**RE: ENGINEERING RESPONSE TO SUBMISSIONS RELATING TO SSD 9227 - PROPOSED AMITY COLLEGE SCHOOL CAMPUS AT NO.85 BYRON ROAD AND NO.63 INGLEBURN ROAD, LOTS 1 & 2 DP 525996, LEPPINGTON, NSW**

Martens and Associates (MA) have undertaken a review of Camden Council's submission to the SSDA submission in a letter dated 8<sup>th</sup> October 2019 (attached). This response focuses on Councils' comments relating to civil engineering matters.

Council comments in Table 1 below relate to the MA engineering plan set submitted for the SSDA, drawing reference P1806493PS01-R09 revision G dated 24/07/2019.

DRAWING TITLE				
DRAINAGE PLAN (STAGE 1)				
PROJECT NO.	PLANSET NO.	RELEASE NO.	DRAWING NO.	REVISION
P18064.93	PS01	R09	PS01-E101	D

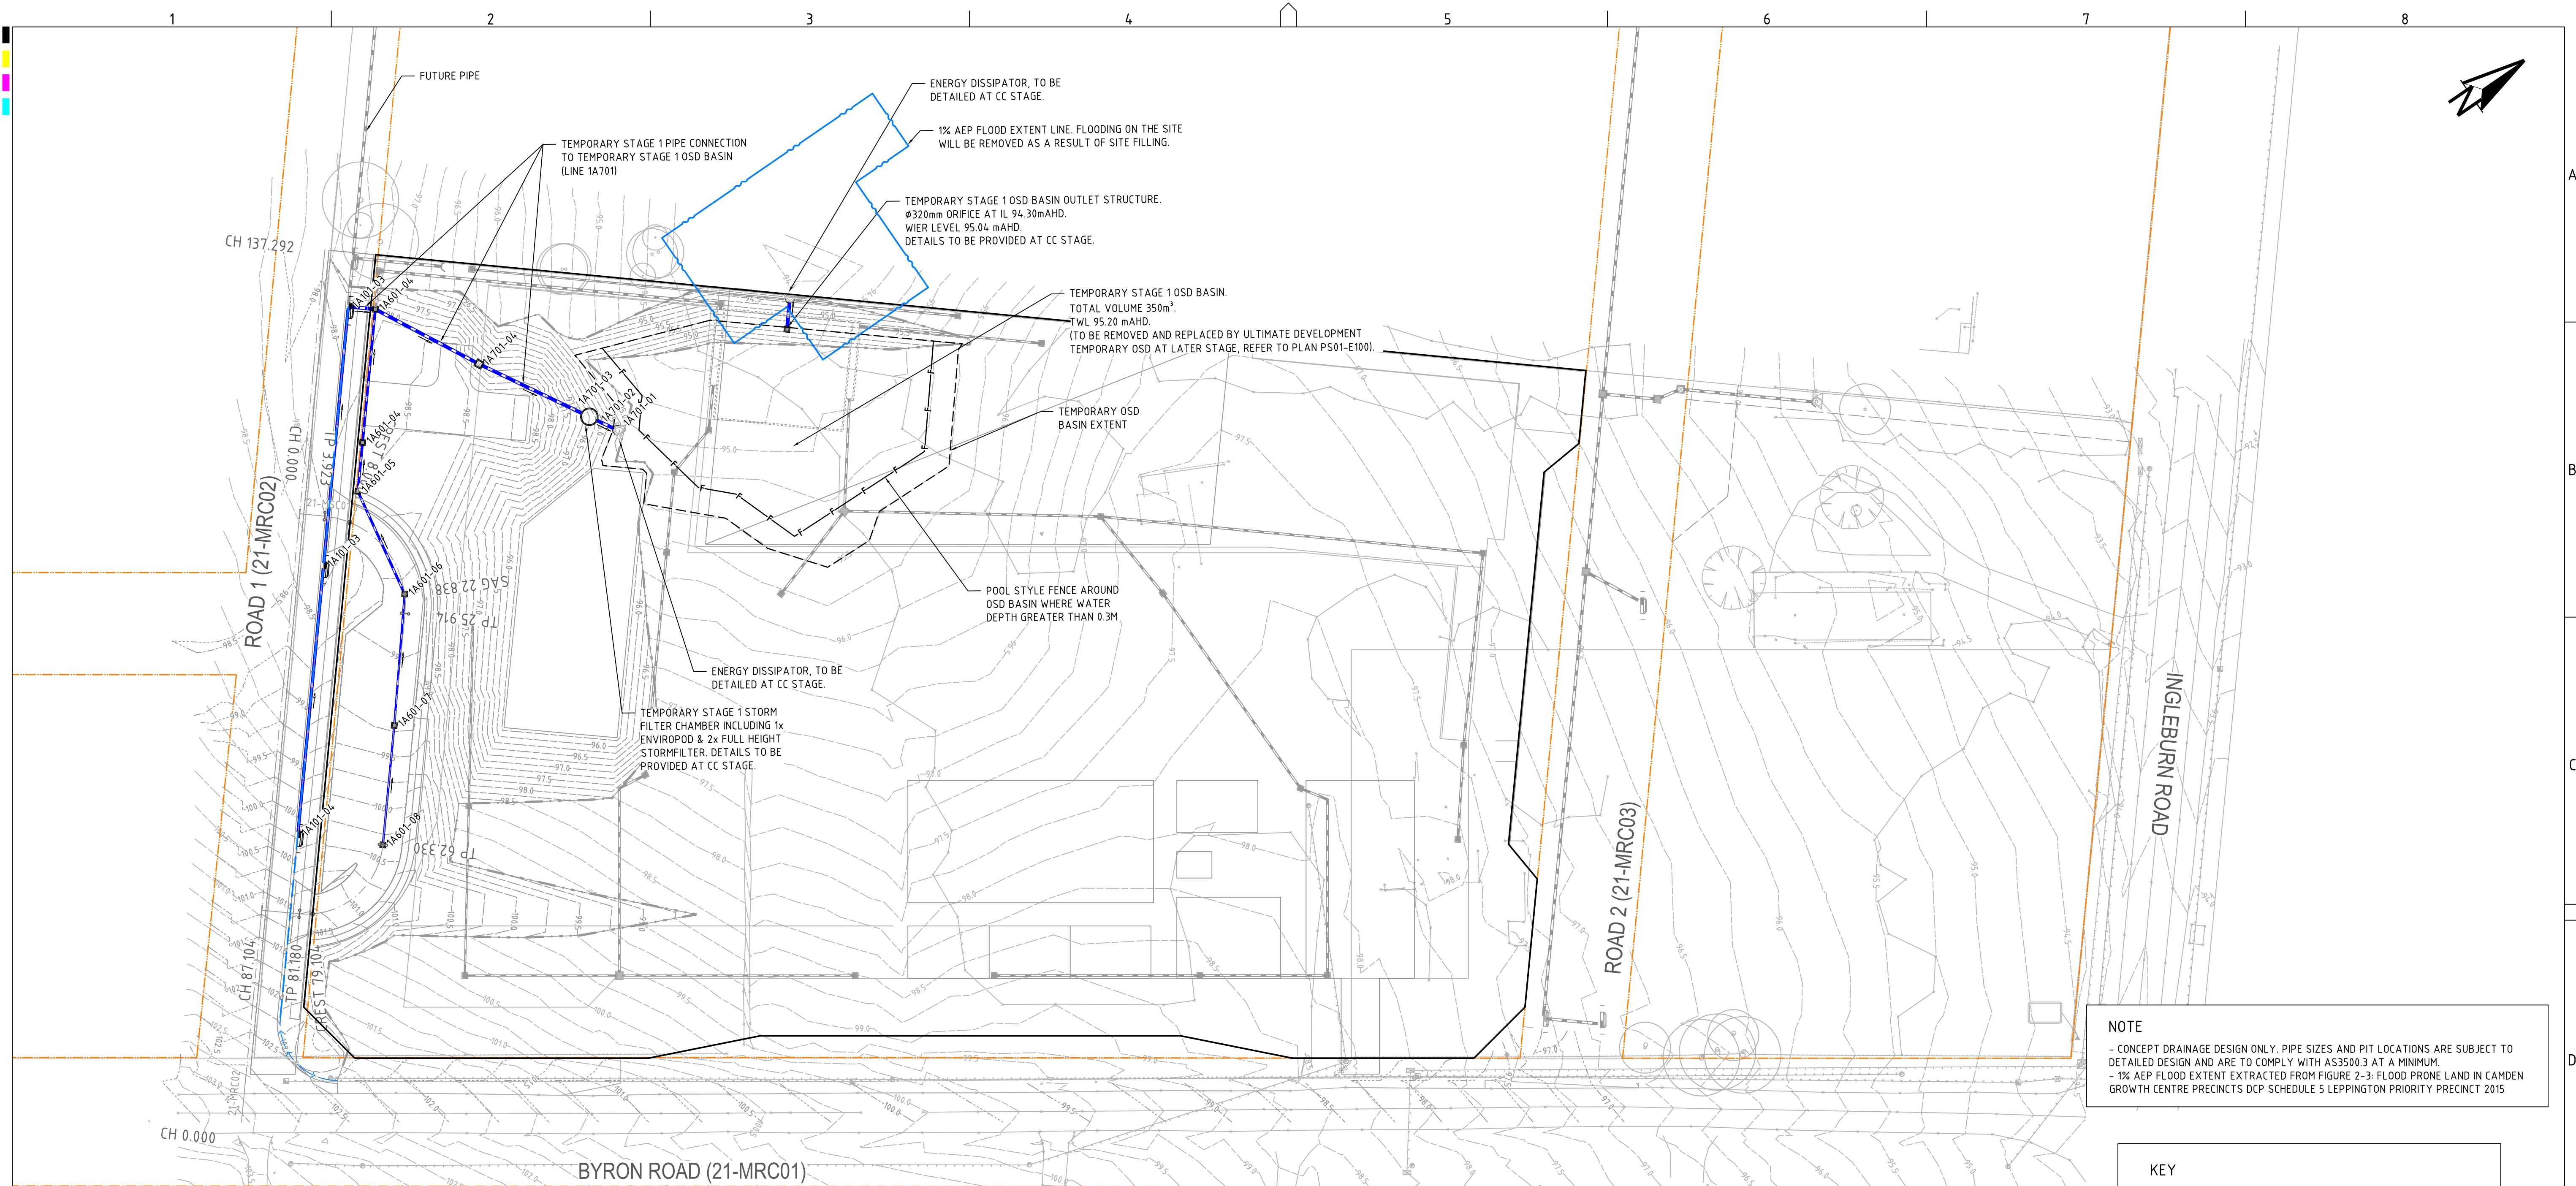
23	The final pavement design shall be carried out in accordance with a geotechnical site investigation by a suitably qualified engineer.	Noted. This can be incorporated as a condition of consent.
24	Road designs are to be in accordance with Council's Engineering Specifications.	Noted. This can be incorporated as a condition of consent.
25	Stormwater drainage designs are to be in accordance with Council's Engineering Design Specifications.	Noted. This can be incorporated as a condition of consent.
26	All sag pits must have minimum 2.4m lintels and on-grade pits must have minimum 1.8m lintels.	Noted. This can be incorporated as a condition of consent.
27	Drainage line 1A701 (stage 1) must be clarified (refer to drainage longitudinal section drawing no. PS01-E310 revision A).	The drainage design has been amended to discharge water to Pluto Avenue (refer to Item 11). As a consequence of these changes, the stage 1

<p>drainage line 1A701 has been made redundant and is no longer proposed.</p> <p>Line 1A701 has therefore been removed from the latest updated engineering plans.</p>
28	A MUSIC model must utilise Council's Music Link parameters when modelling the water quality aspect of the stormwater management system.	<p>Council's DCP and Engineering Design Specification do not have any requirements relating to MUSIC-link.</p> <p>An inconsistency is noted in Council's DCP and Engineering Design Specification [DCP requires no adverse impact on water quality (2019, Section 2.3), while Council's Engineering Specification requires 90%/85%/65%/45% reduction rates for GP, TSS, TP and TN to be achieved for the site (2009, Table 3.3.9)]. MA adopted the Water Quality targets specified in Council's Engineering Specification.</p> <p>Notwithstanding this, the MUSIC models were updated in accordance with Council's MUSIC-link and comply with Council's water quality requirements.</p>

DRAWING TITLE				
EARTHWORKS GRADING PLAN (ULTIMATE DEVELOPMENT)				
PROJECT NO.	PLANSET NO.	RELEASE NO.	DRAWING NO.	REVISION
P18064.93	PS01	R11	PS01-C100	H

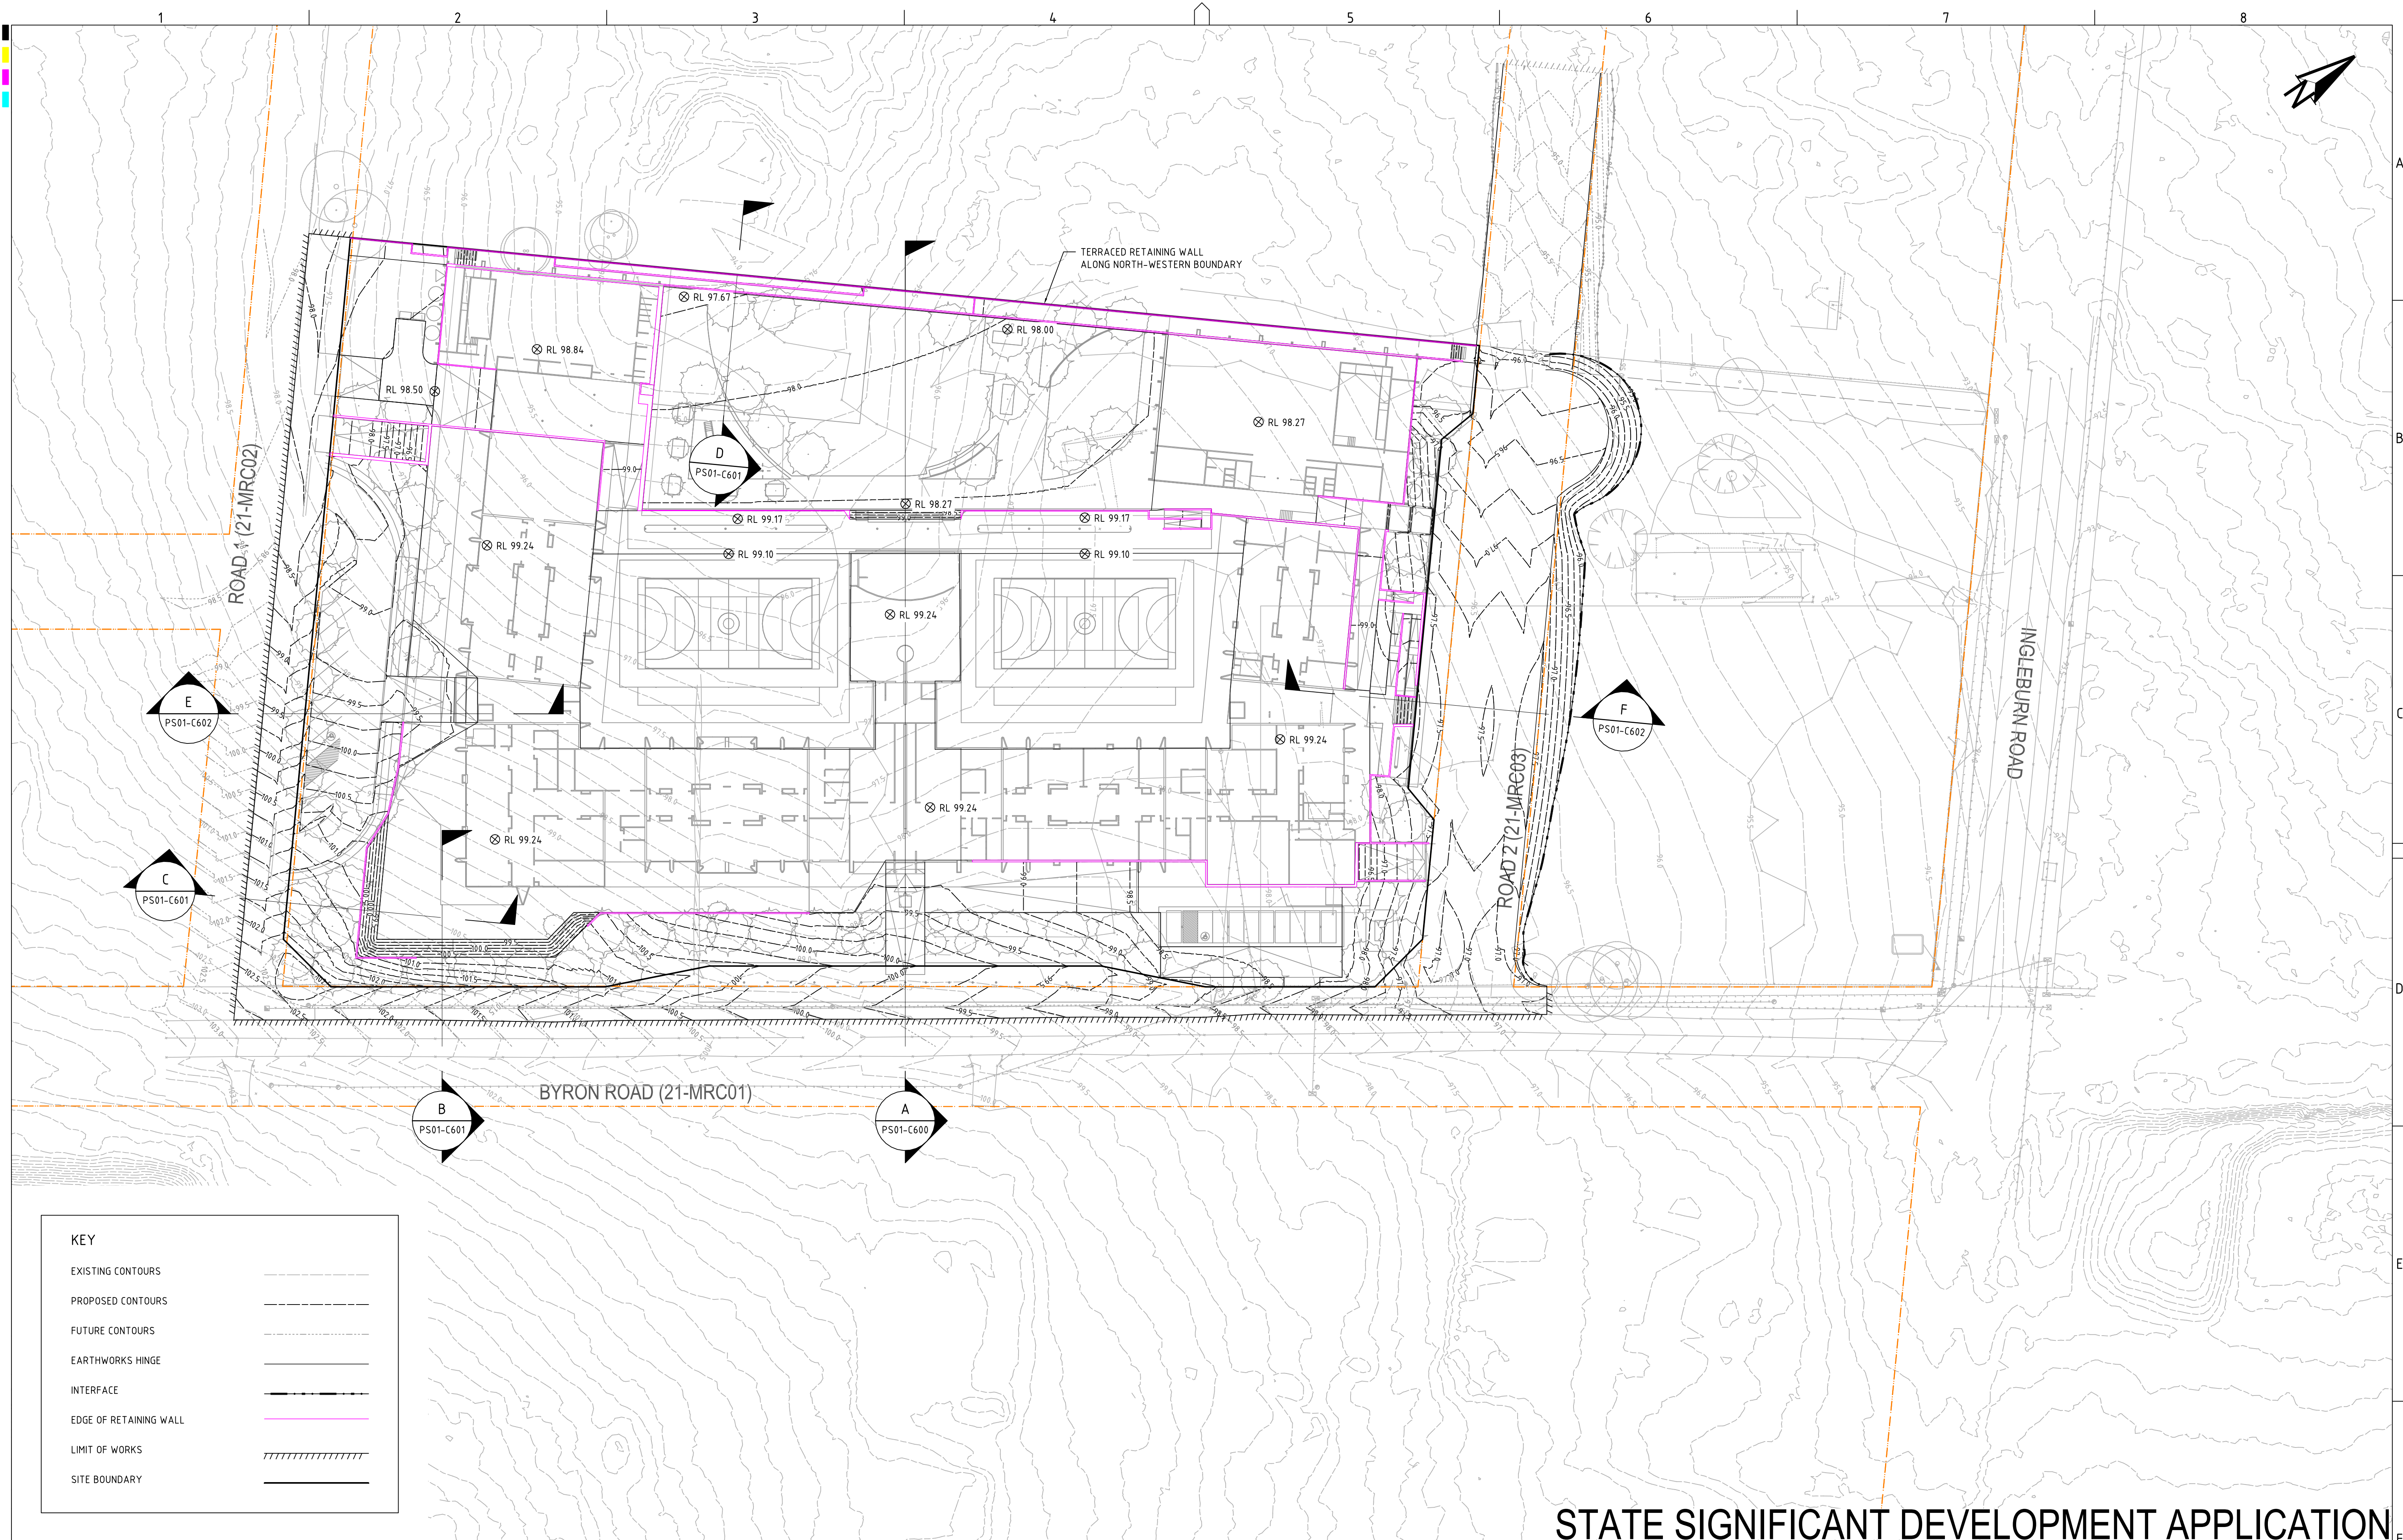
19	The design for road 2 shall be extended 50m into the adjoining property (69 Ingleburn Road) to demonstrate that the design is suitable for the adjoining property and vicinity.	The engineering plans have been updated to include the extension of road 2. Refer to the attached plan ref P1806493PS01
20	A bond should be provided to decommission the temporary turning head at end of road 2 and reconstruct it to its ultimate condition when the adjoining property is developed and the turning head is no longer required. This can be addressed via a condition of consent.	Noted. This can be incorporated as a condition of consent.
21	A road works application pursuant to Section 138 of Roads Act 1993 is required for works carried out along Pluto and Byron Roads.	Noted. This can be incorporated as a condition of consent.
22	The Byron Road road pavement must be constructed at the same stage as the bus bay.	Noted. This can be incorporated as a condition of consent.
